**Ingleburn Resource Recovery Facility (SSD 8593)
Response to Submissions**

Attachment 1: Additional Information

DRAWING STATUS		SHEET SIZE
NOT FOR CONSTRUCTION		A1
PROJECT REF No.	DRAWING No.	SCALE
180009	TURN01	1:250
		REVISION
		K

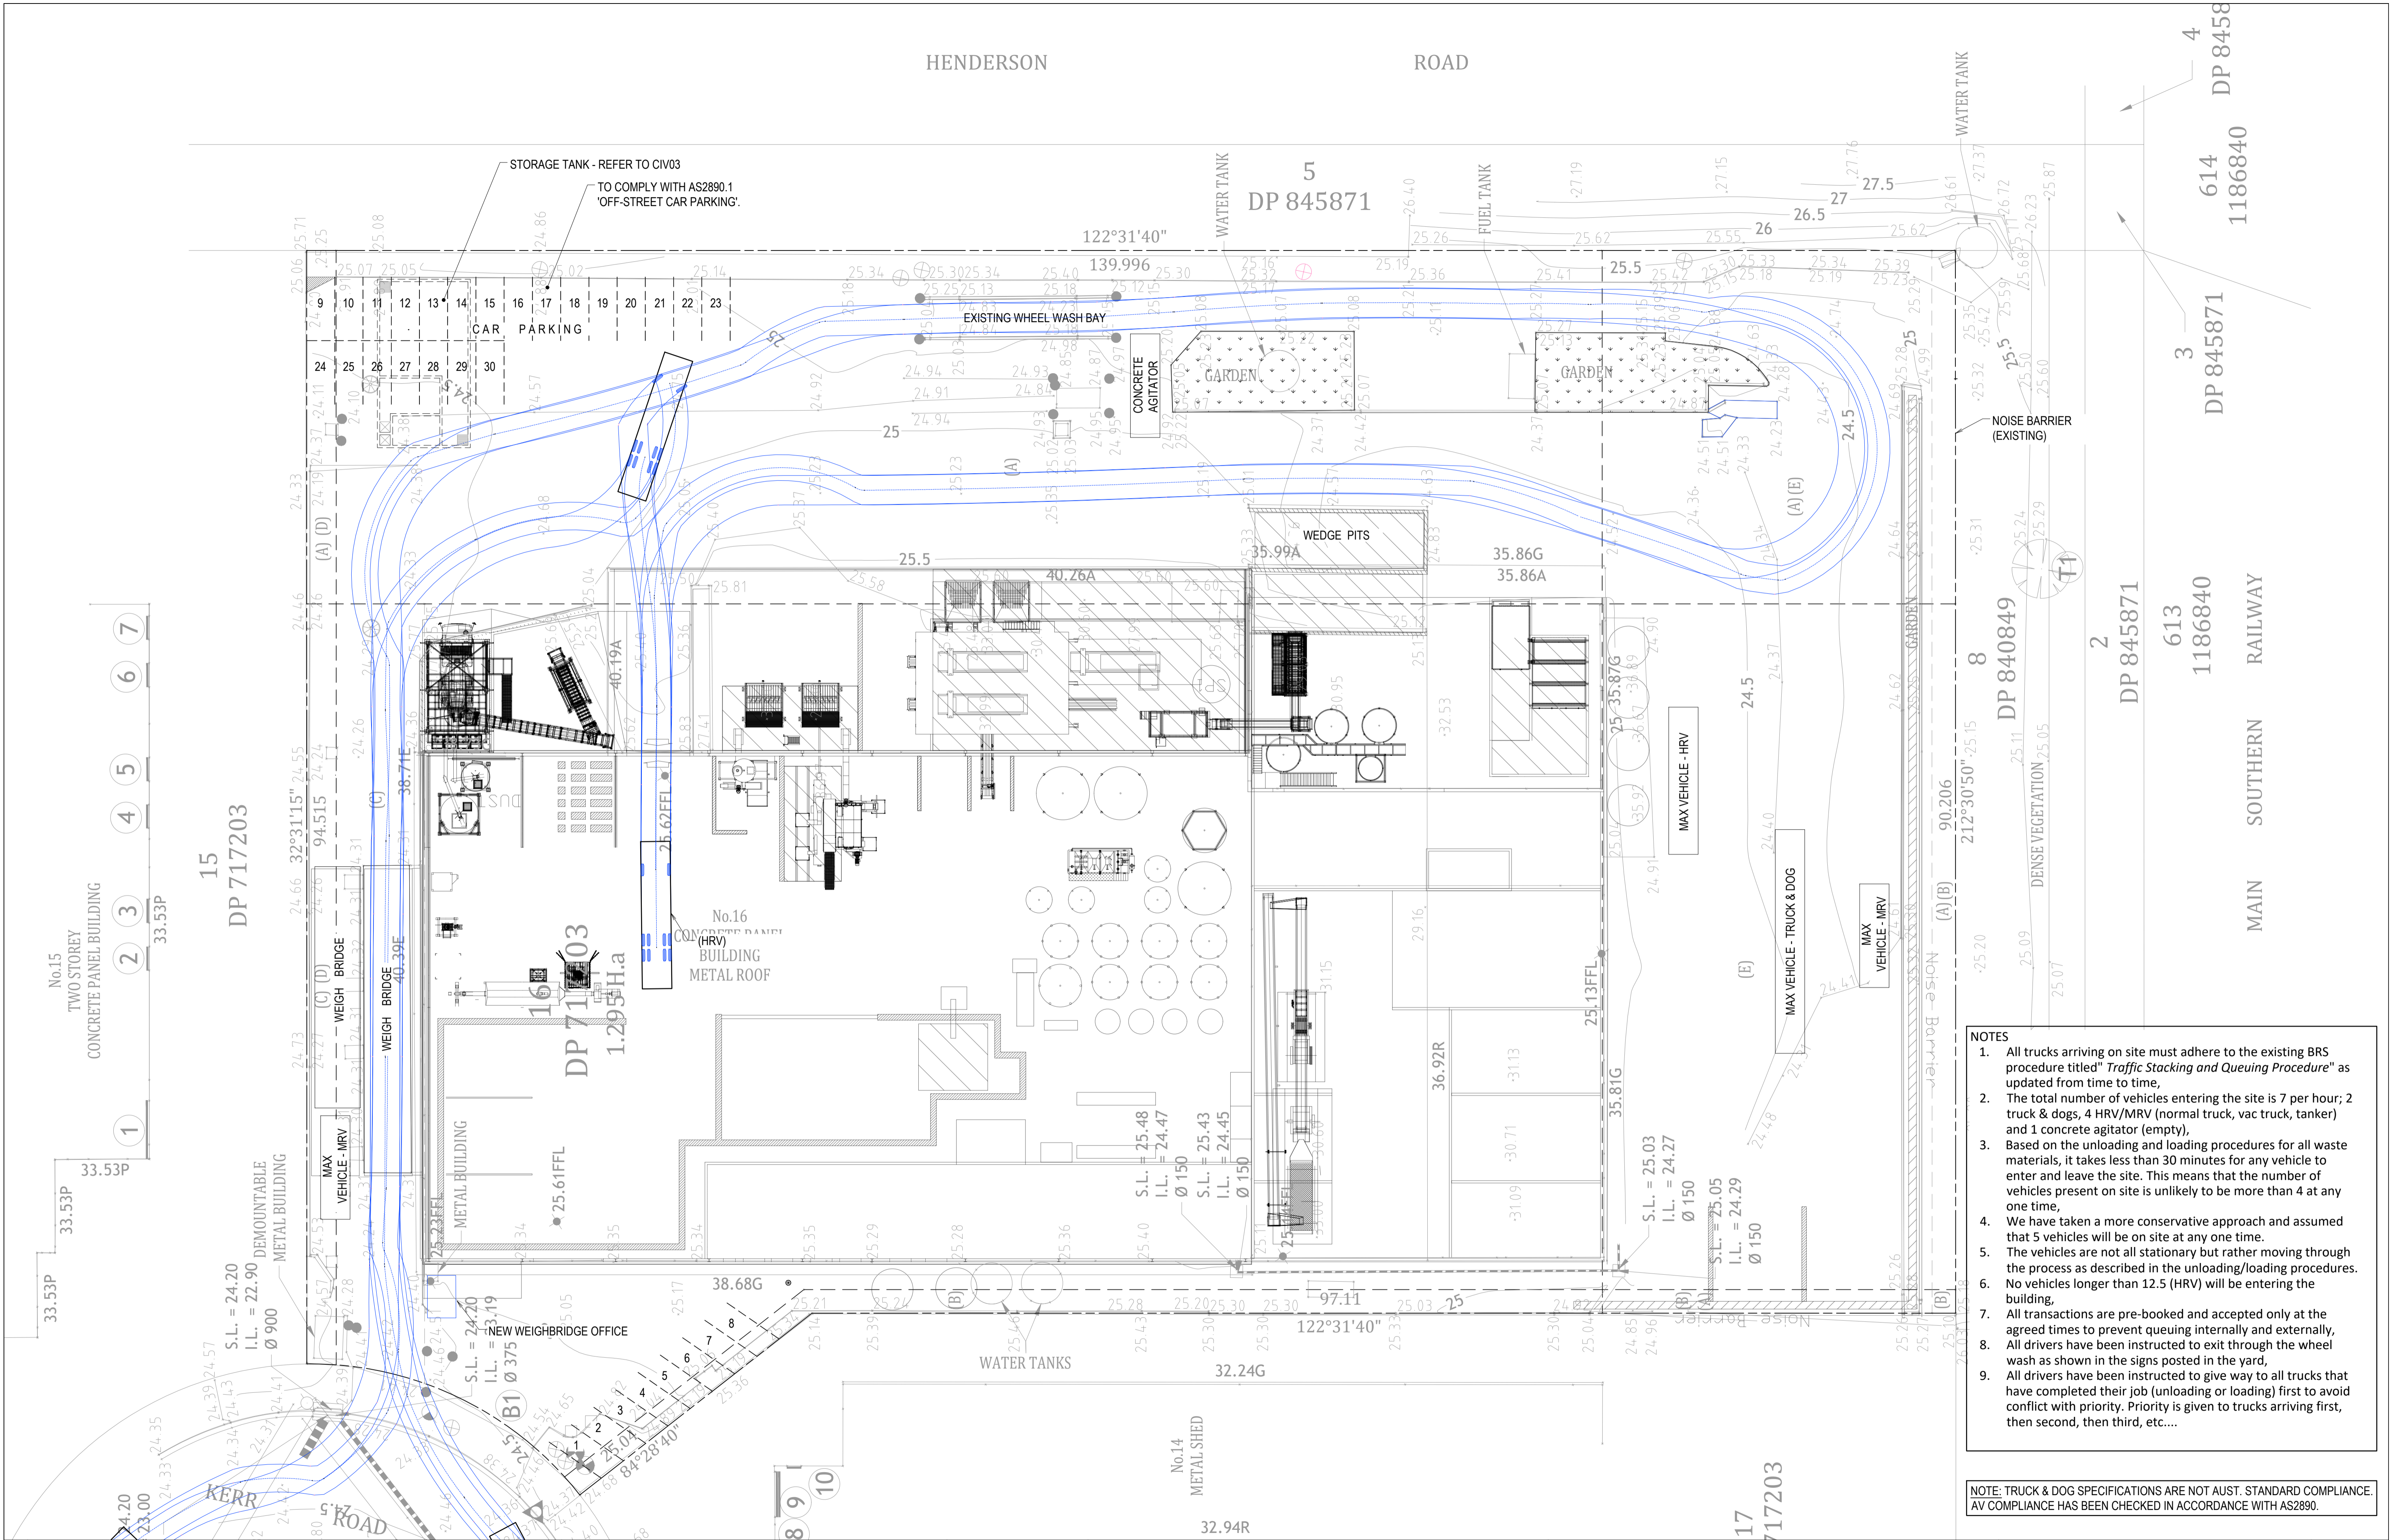
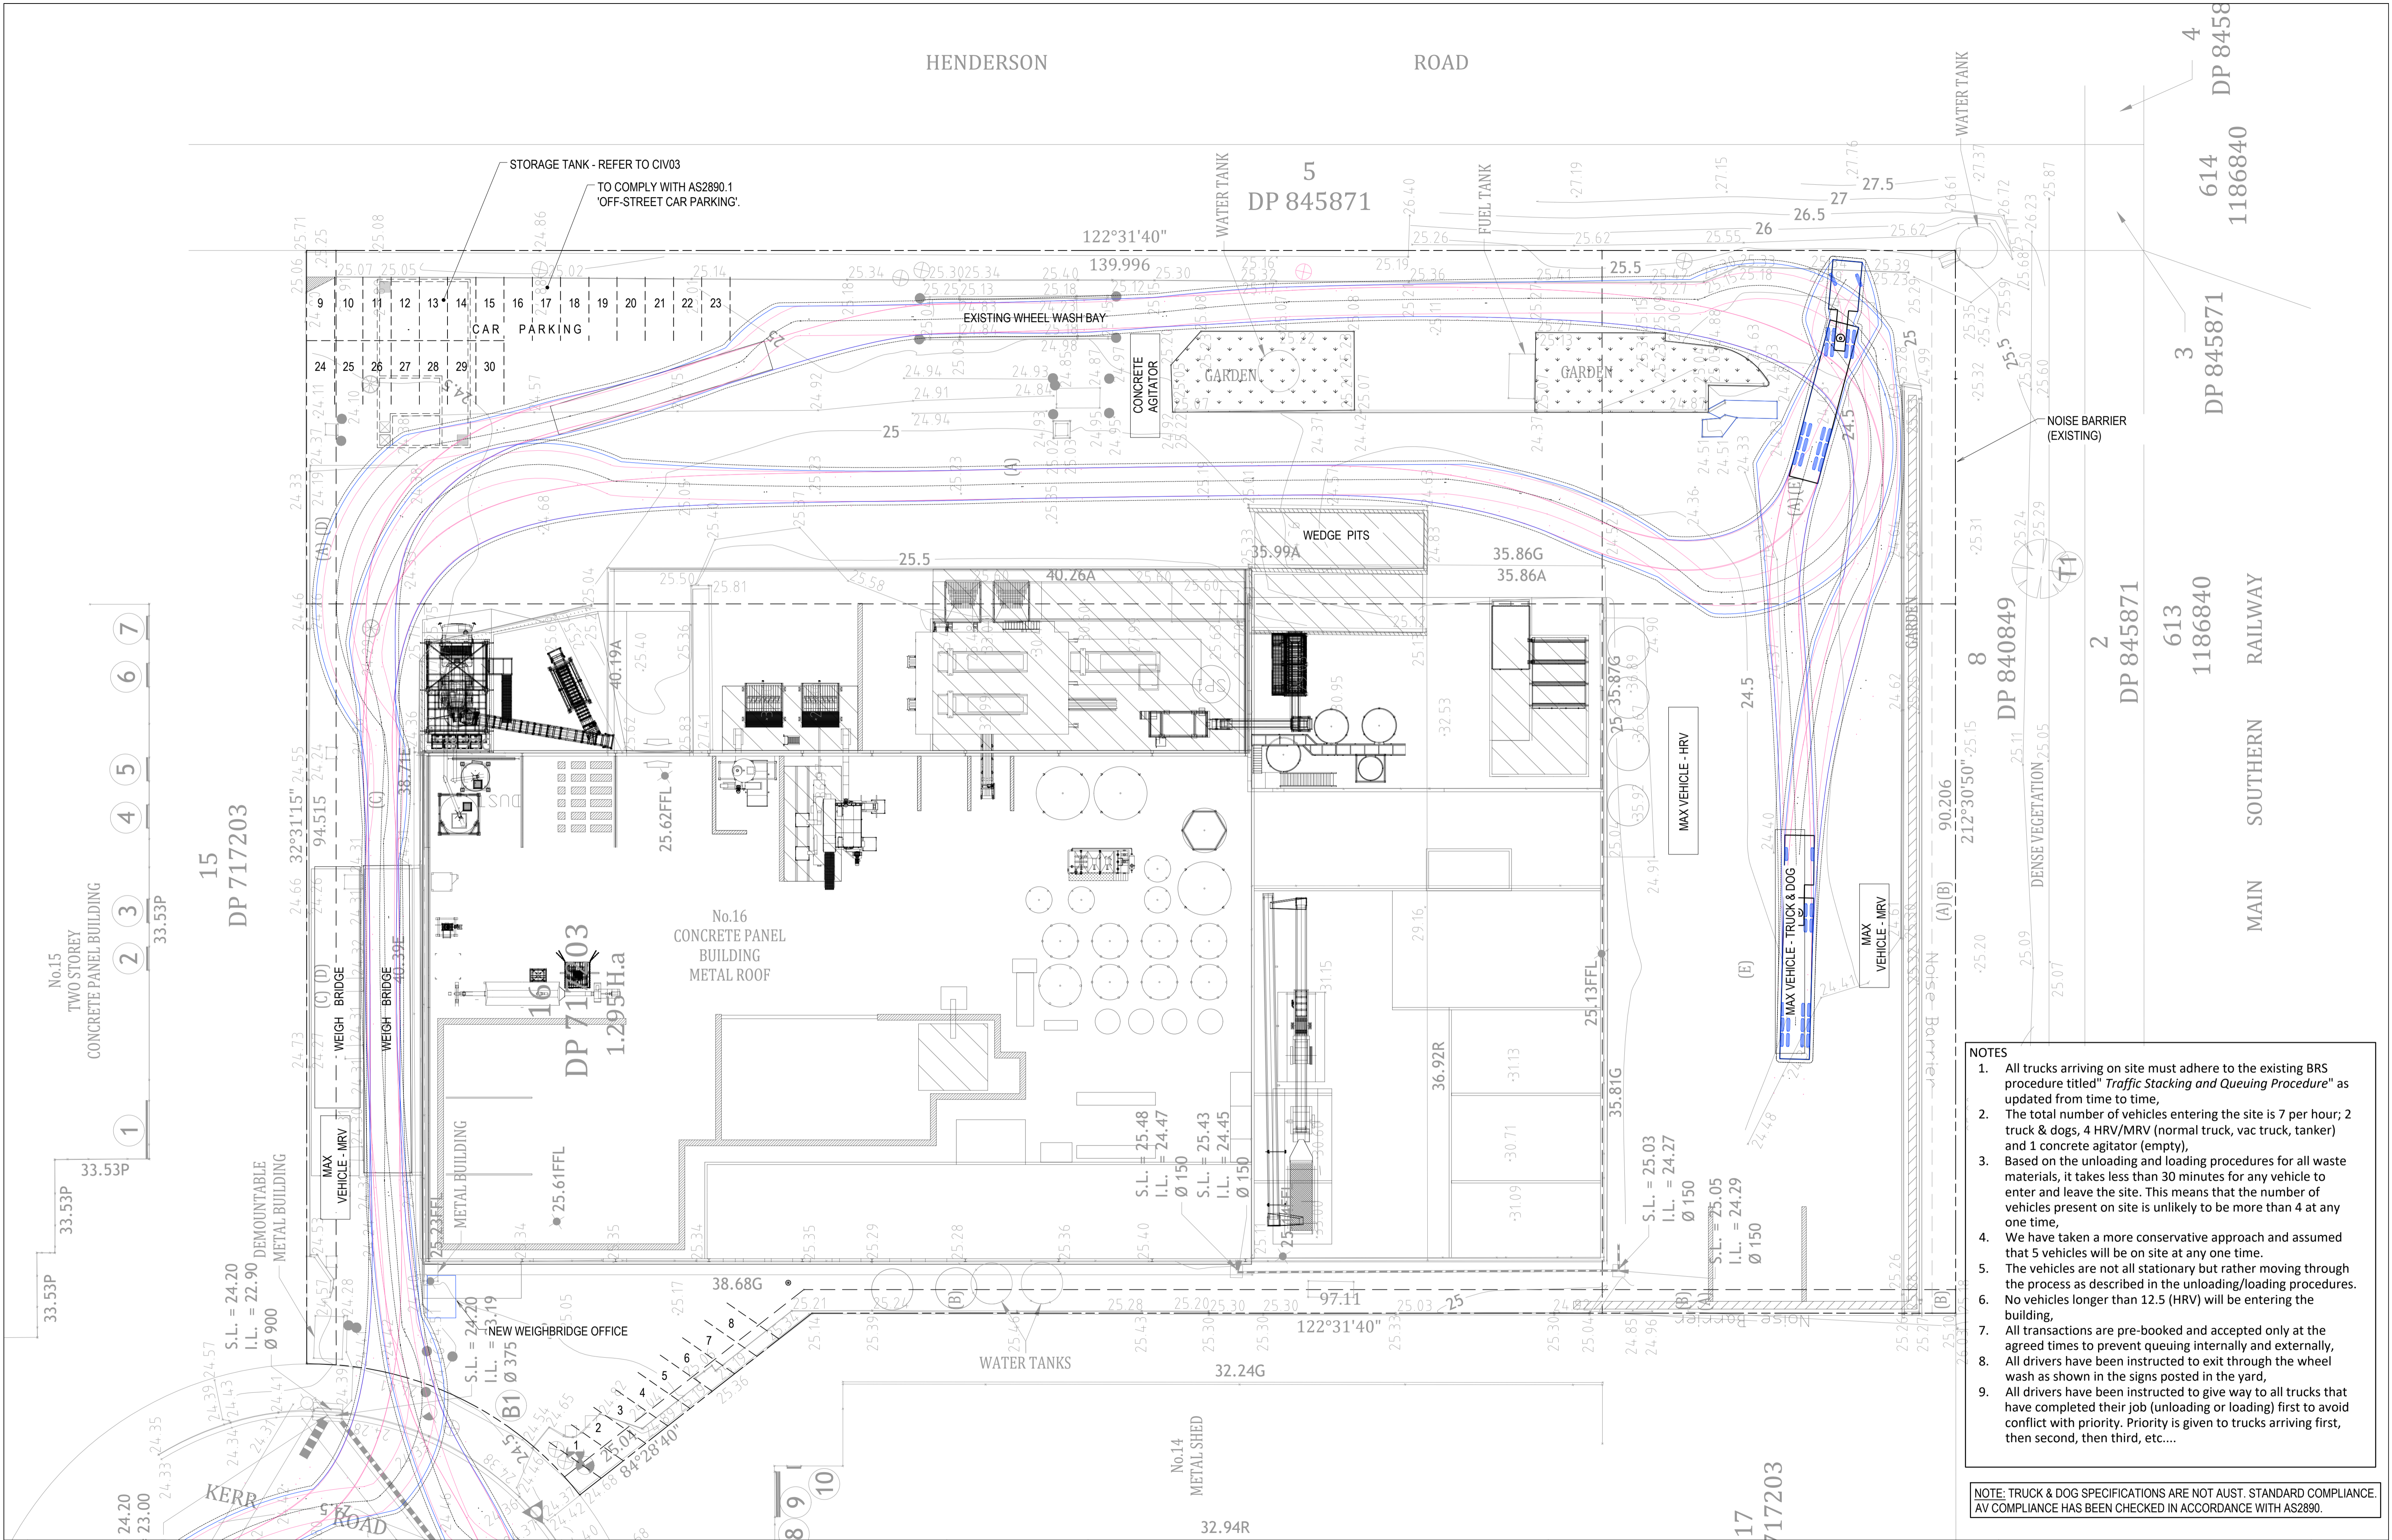
- The temporary storage area (solid materials, skip bins and solids for transfers) and staff parking area appears to be located in the heavy vehicle turning path for B double, articulated vehicle paths and mud waste and smaller trucks. Provide details on how heavy vehicle will be managed and updated plans that show that heavy vehicle safely manoeuvre within the site and the relocation of the receivals area.

- The parking bays appear to be in very close proximity to the vehicle turning path for the concrete agitator. Provide details of how heavy vehicles can safely manoeuvre within the site and not conflict with staff parking.

- The TIA does not assess onsite manoeuvring provide turning path diagrams of all on-site truck manoeuvring is required including:
 - accessing and loading and unloading all stockpiles on the site

- Front end loaders manoeuvring in and out of the building through the roller doors
 - truck manoeuvring in and out of the "loading" area at the eastern corner of the site

- trucks manoeuvring in the south-east side of the building
 - trucks manoeuvring in and out of the Concrete plant area and still allow trucks to enter the shed
